**EL PASO COUNTY PLANNING AND  
 COMMUNITY DEVELOPMENT  
 DEPARTMENT**

**GRADING AND EROSION CONTROL PLAN CHECKLIST  
 PPR-21-020**

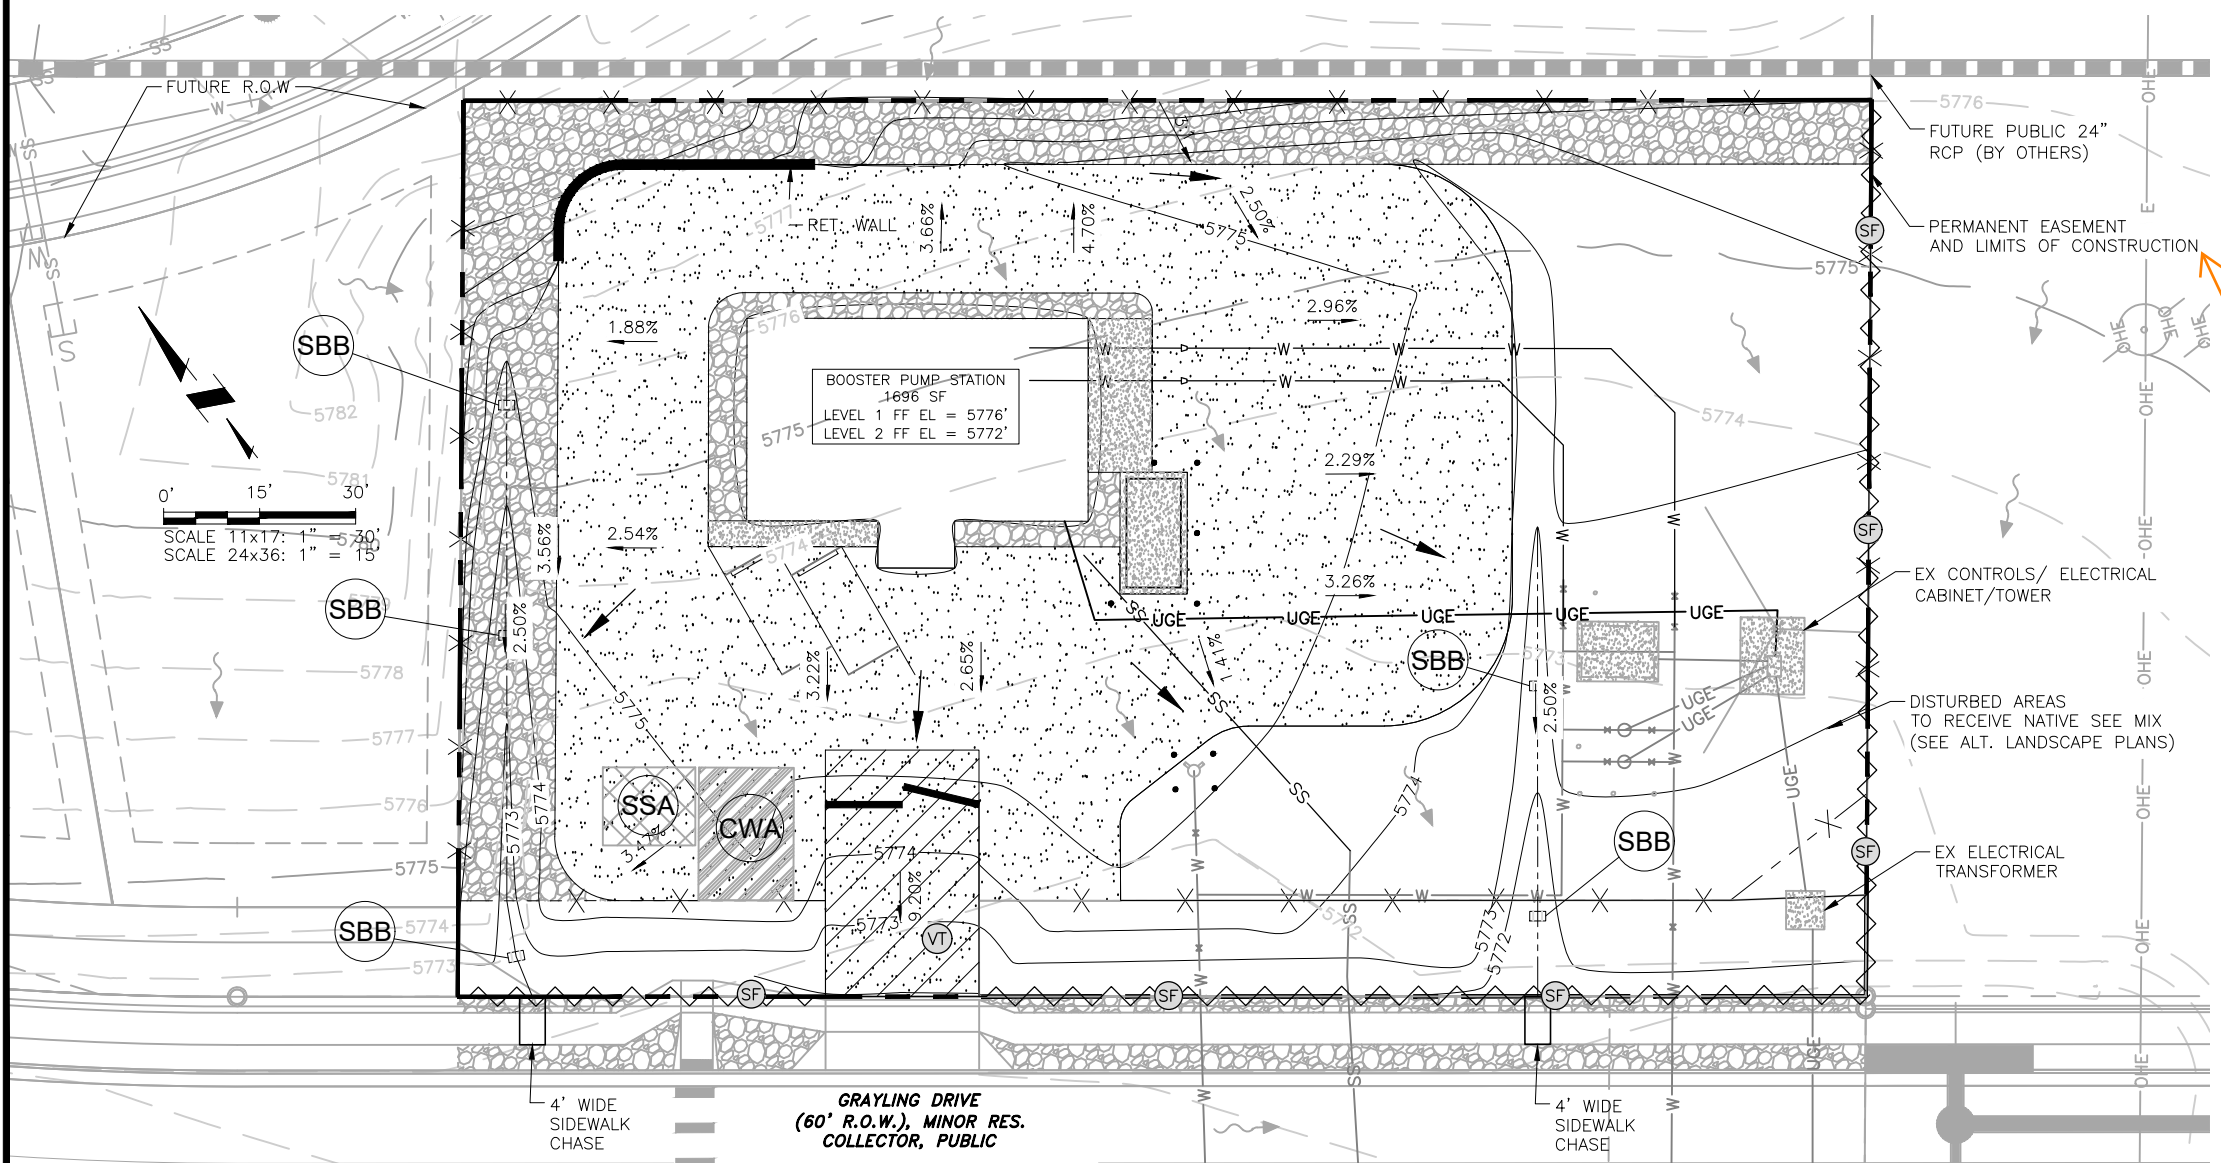
l	Existing and proposed contours 2 feet or less (except for hillside).	X	Y
m	Limits of disturbance delineating all anticipated areas of soil disturbance. <span style="border: 1px solid black; padding: 2px;">See comment on Sht C15</span>	X	N
n	Identify and protect areas outside of the construction site boundary with existing fencing, construction fencing or other methods as appropriate.	X	Y
o	Offsite grading clearly shown and called out.	X	Y
p	Areas of cut and fill identified. <span style="border: 1px solid black; padding: 2px;">See comment on Sht C15</span>	X	N
q	Conclusions from soils/geotechnical report and geologic hazards report incorporated in grading design (slopes, embankments, materials, mitigation, etc.)	X	Y
r	Proposed slopes steeper than 3:1 with top and toe of slope delineated. Erosion control blanketing or other protective covering required.	X	Y
s	Stormwater flow direction arrows.	X	Y

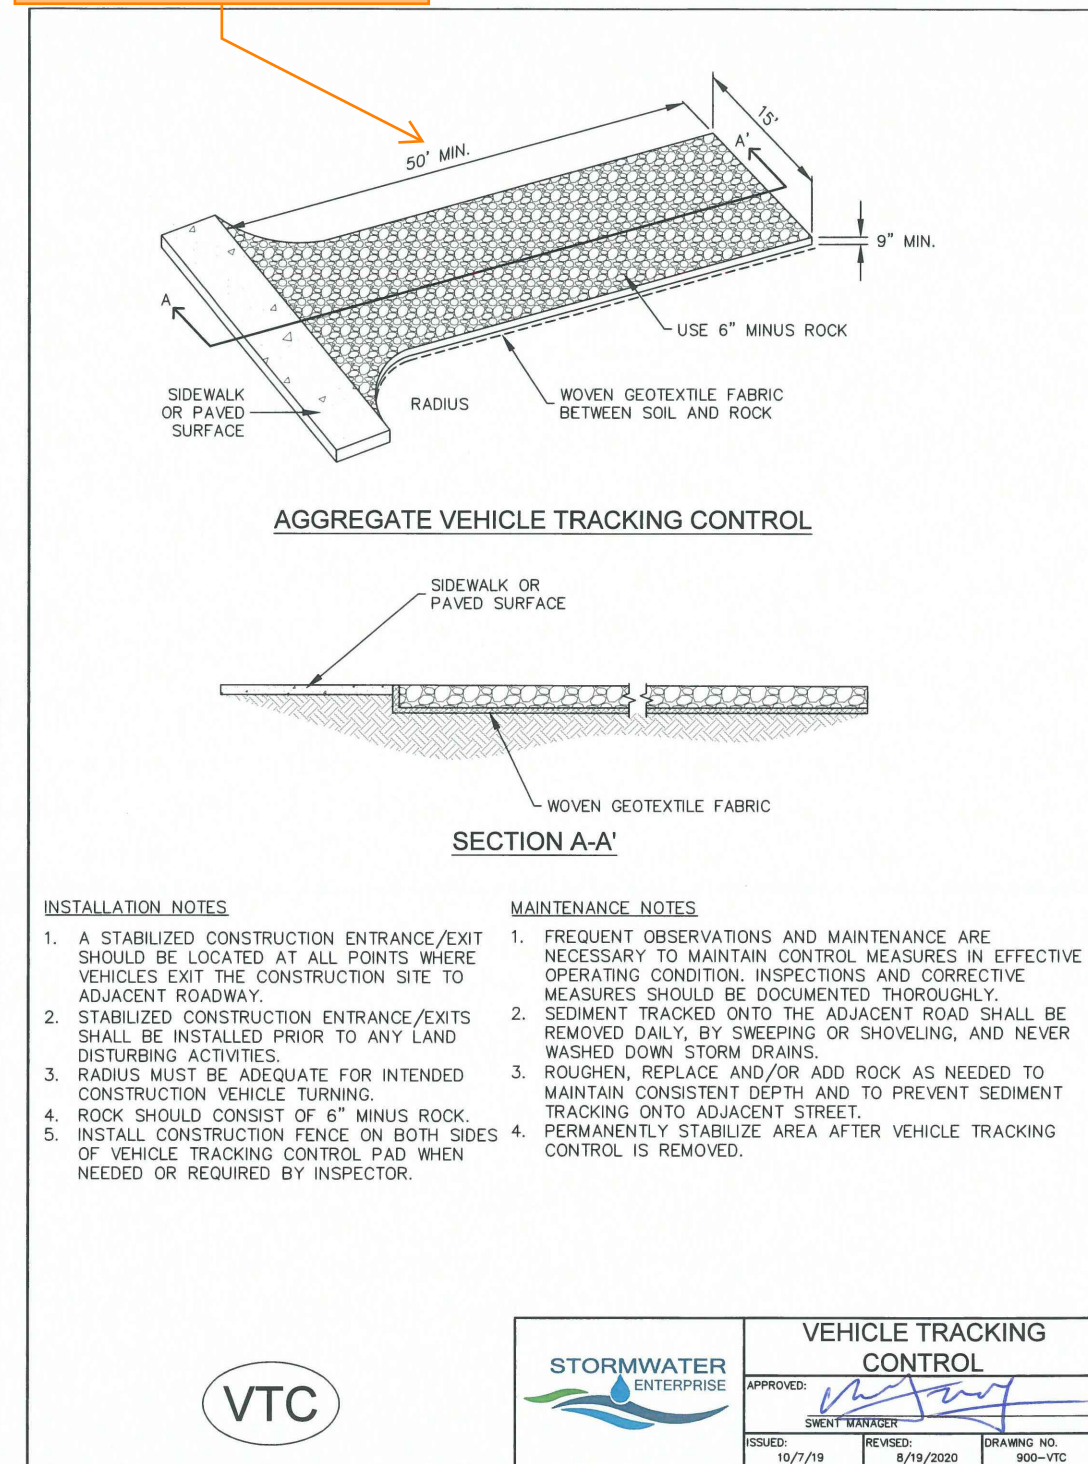
t	Location of any dedicated asphalt / concrete batch plants.	N/A	N/A
u	Areas used for staging, storage of building materials, soils (stockpiles) or wastes. The use of construction office trailers requires PCD permitting.	X	Y
v	All proposed temporary construction control measures, structural and non-structural. Temporary construction control measures shall be identified by phase of implementation to include "initial," "interim," and "final" or shown on separate phased maps identifying each phase.	X	Y
w	Vehicle tracking provided at all construction entrances/exits. Construction fencing, barricades, and/or signage provided at access points not to be used for construction.	X	Y
x	Temporary sediment ponds provided for disturbed drainage areas greater than 1 acre.	N/A	N/A
y	Dewatering operations to include locations of diversion, pump and discharge(s) as anticipated at time of design.	N/A	N/A
z	All proposed temporary construction control measure details. Custom or other jurisdiction's details used must meet or exceed EPC standards. <span style="border: 1px solid black; padding: 2px;">See comment on Sht C16</span>	X	N
